DRB Application No.: 06DRB-00718 (P&F)
Project Name ALVARADO GARDENS NO. 1
Agent: Mark Holman

Project # 1004844
Phone No.: 345-1945

**CITY OF ALBUQUERQUE
PLANNING DEPARTMENT
May 31, 2006
DRB Comments**

RE: tract 31, Alvarado Gardens, No. 1

A REPLAT OF THE W/2 OF THE E/2 OF TRACT 31, ALVARADO GARDENS UNIT ONE
WITHIN SW 1/4, PROJECTED SECTION 6, T.10N., R.3E., N.M.P.M.,
TOWN OF ALBUQUERQUE GRANT
ALBUQUERQUE, BERNALILLO COUNTY, NEW MEXICO

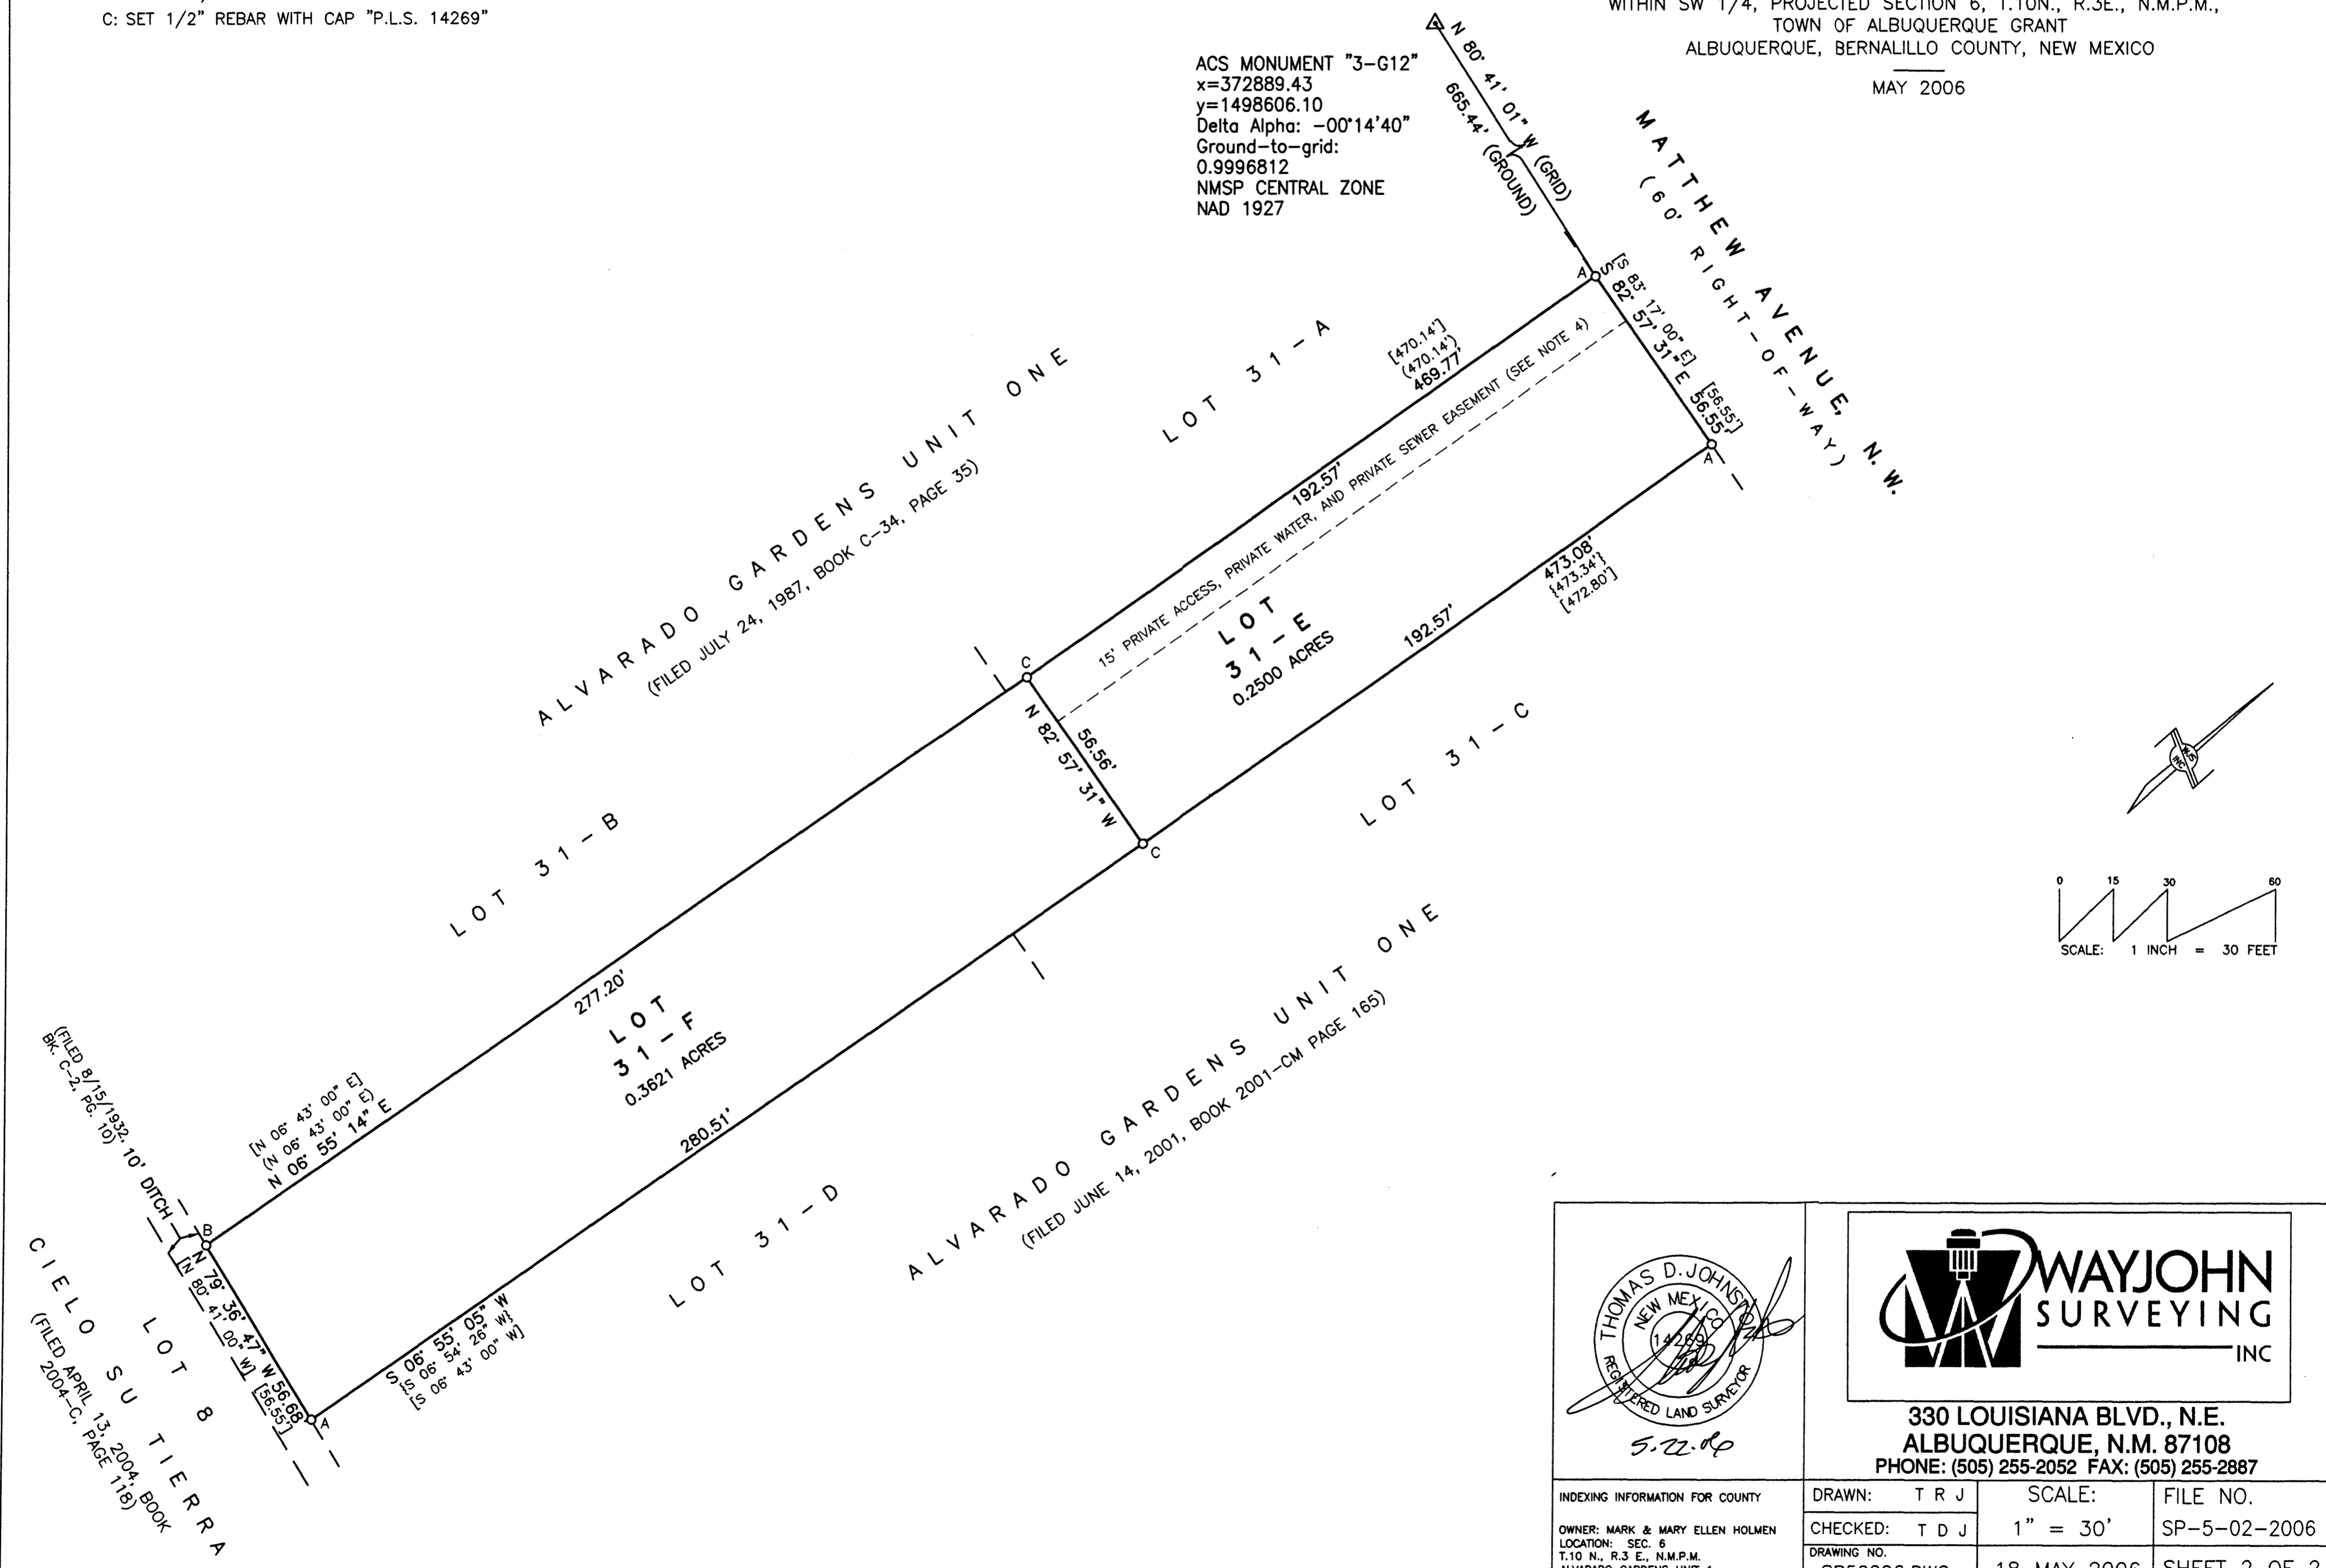
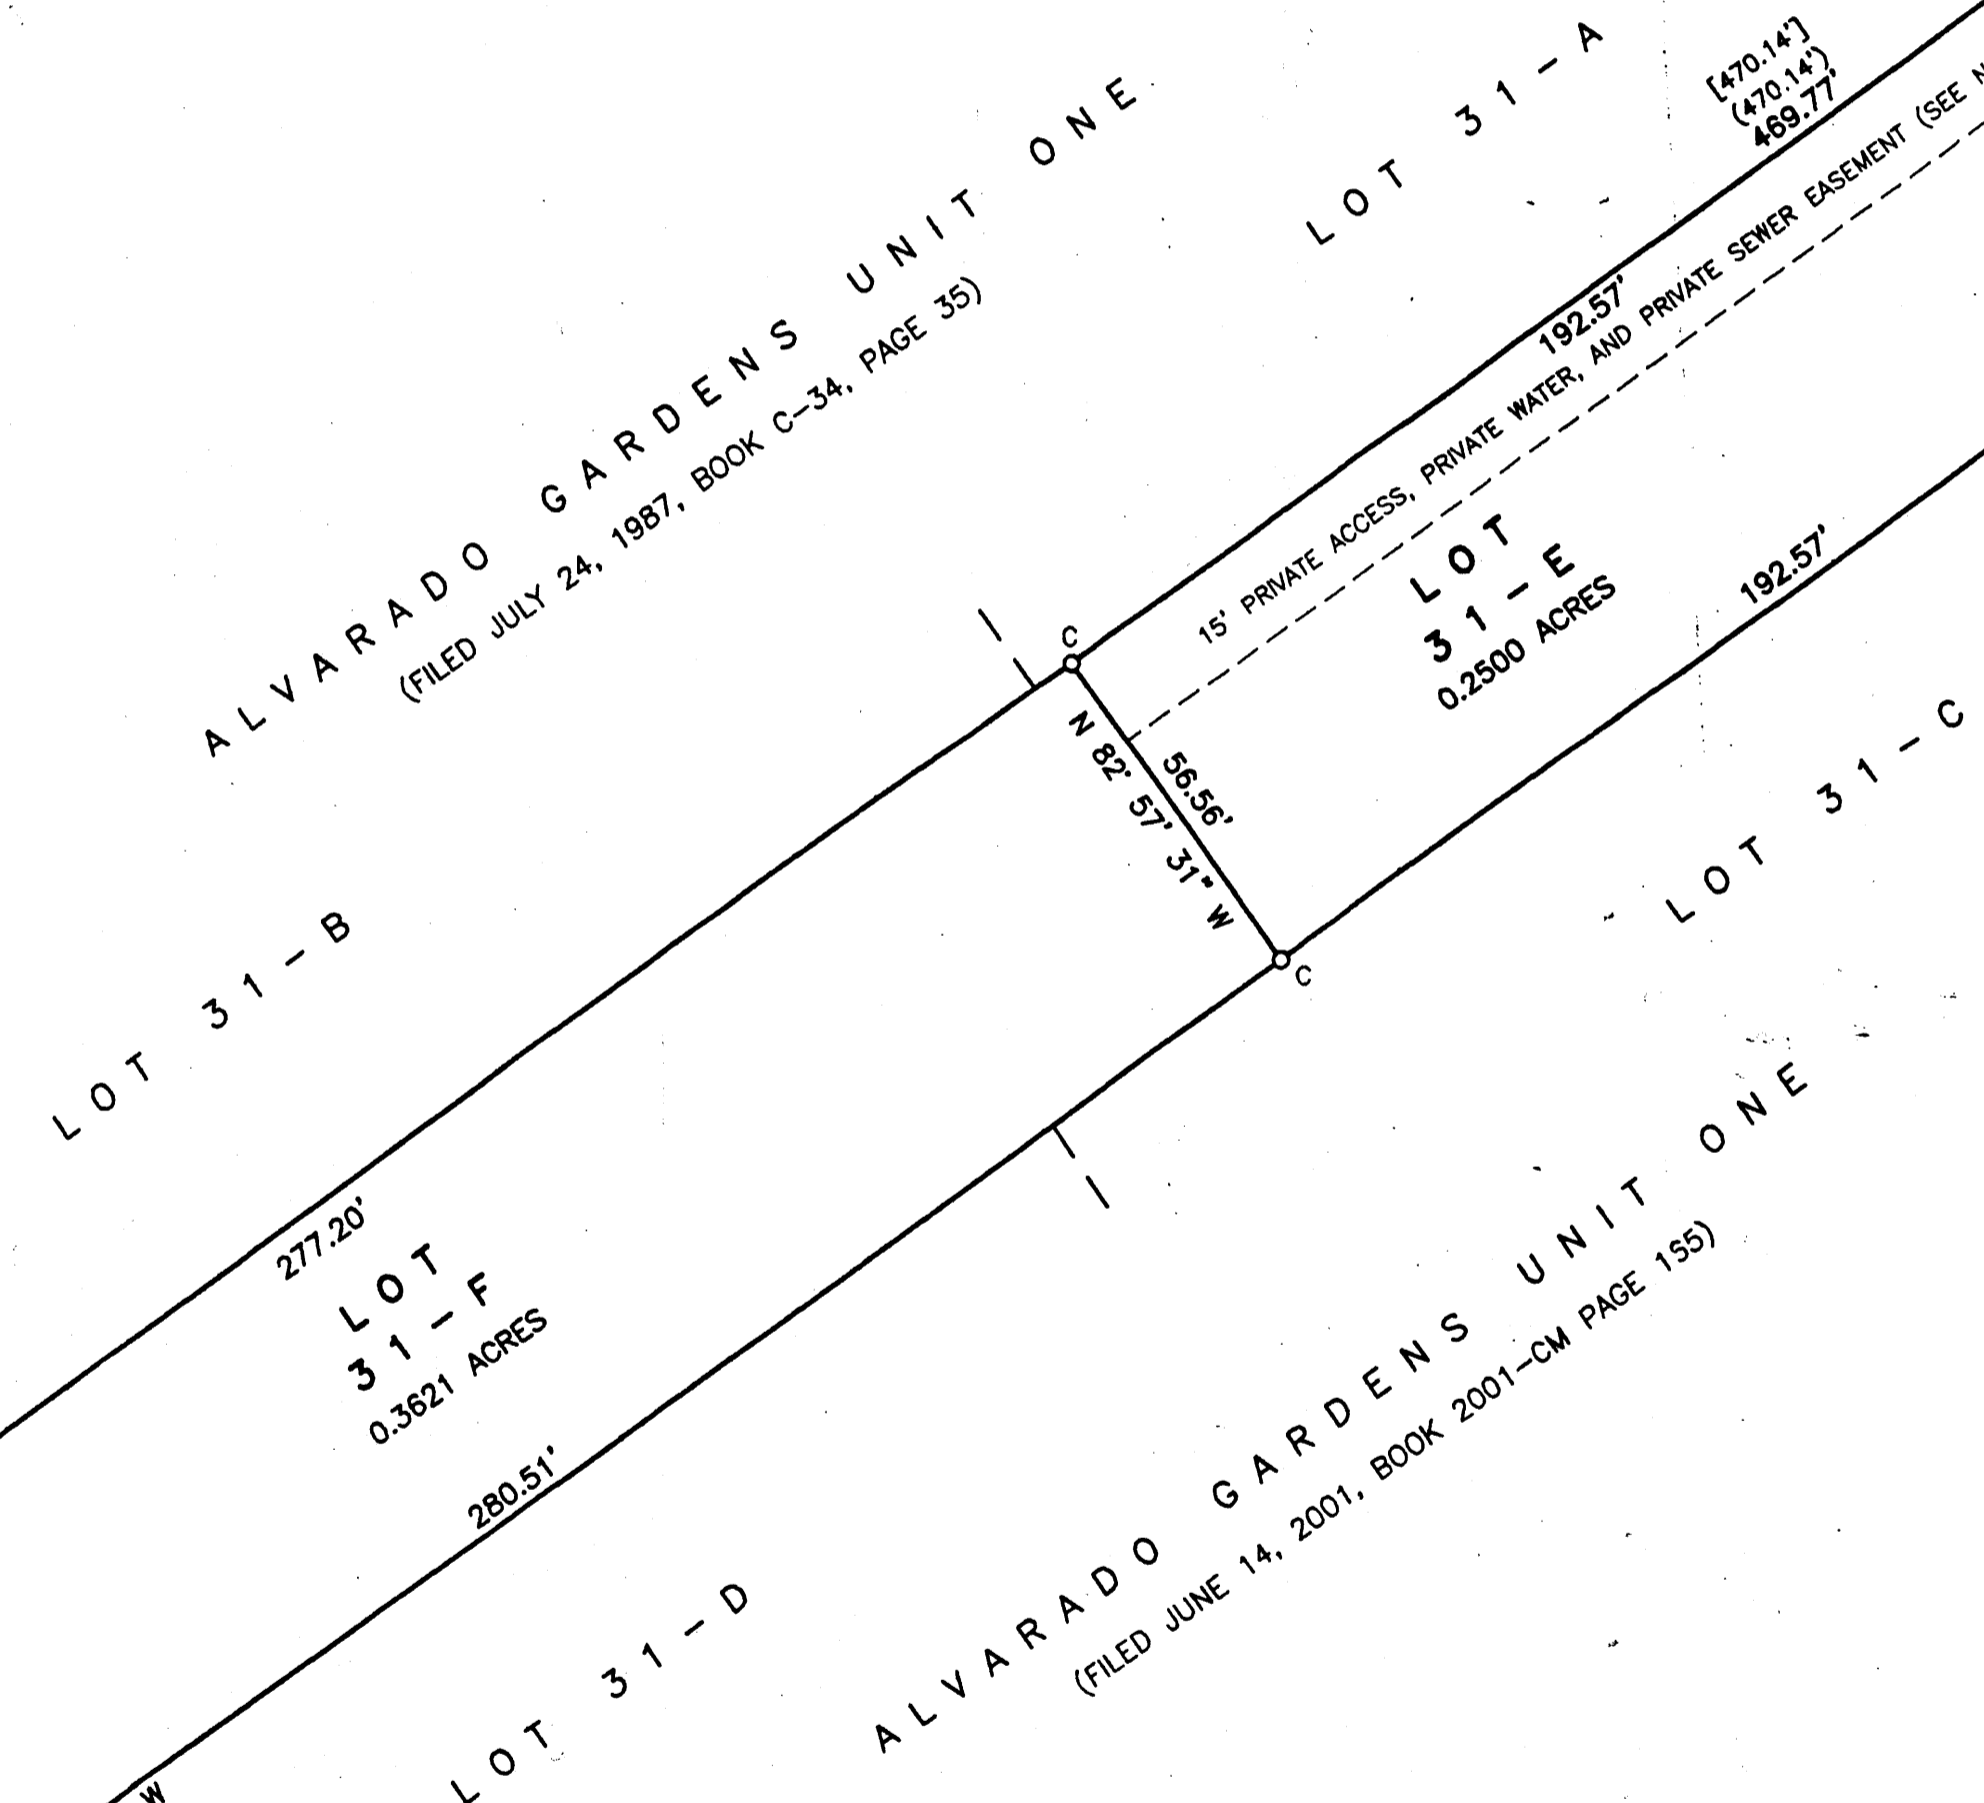
<sup>1930's -
40's</sup>
When was this lot platted? The minimum lot width for RA2 zoning is 75 feet. The lot next to it appears to be similar. Were these two lots just one at some point?

Because the lot is substandard in width, Planning is reluctant to create another substandard lot by approving a lot split.
